From: Gregg, Robert <Robert.Gregg@lancashire.gov.uk>
Sent: 07 November 2018 12:44
To: Stephen Kilmartin
Cc: planning; LHS Customer Service
Subject: APP. 3/2018/0982 - LAND ADJACENT TO 17 BROOKES LANE WHALLEY

Resubmission of planning application 3/2018/0511 with design amendments.

Garaging (Plot 3 and No.19) - BROOKES LANE, WHALLEY

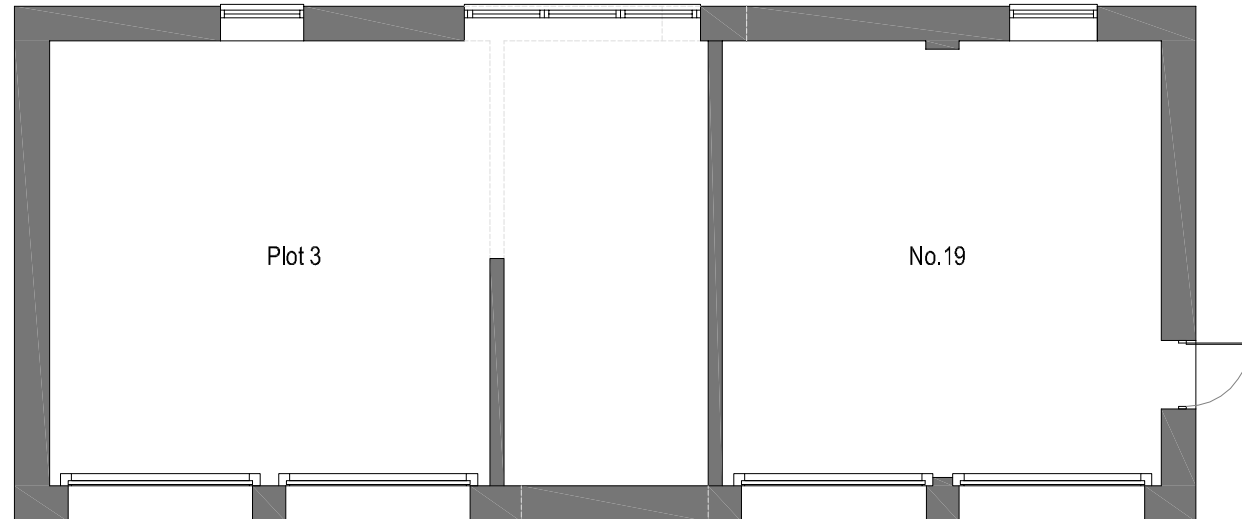
I would like to note that the garages to number 17 and 19 as well as the garages to plot 2 and 3 do not meet the required dimensions set out in Clause 8.3.41 on page 109 from the Manual for Streets. Although, there is however sufficient parking space within the curtilage of each dwelling to accommodate the parking provisions.

Should your council be minded to approve this application then I would request that the following condition be attached to any permission that may be granted

1. Notwithstanding the provisions of the Town and Country Planning (General Development Procedure) Order 1995 and the Town and Country Planning (General Permitted Development) (Amendment) (No 2) (England) Order 2008, or any subsequent Orders or statutory provision re-enacting the provisions of these Orders, all garages shown on the approved plan shall be maintained as such and shall not be converted to or used for living accommodation without the prior written approval of the Local Planning Authority in consultation with the Highway Authority. **Reasons:** To allow for the effective use of the parking areas.
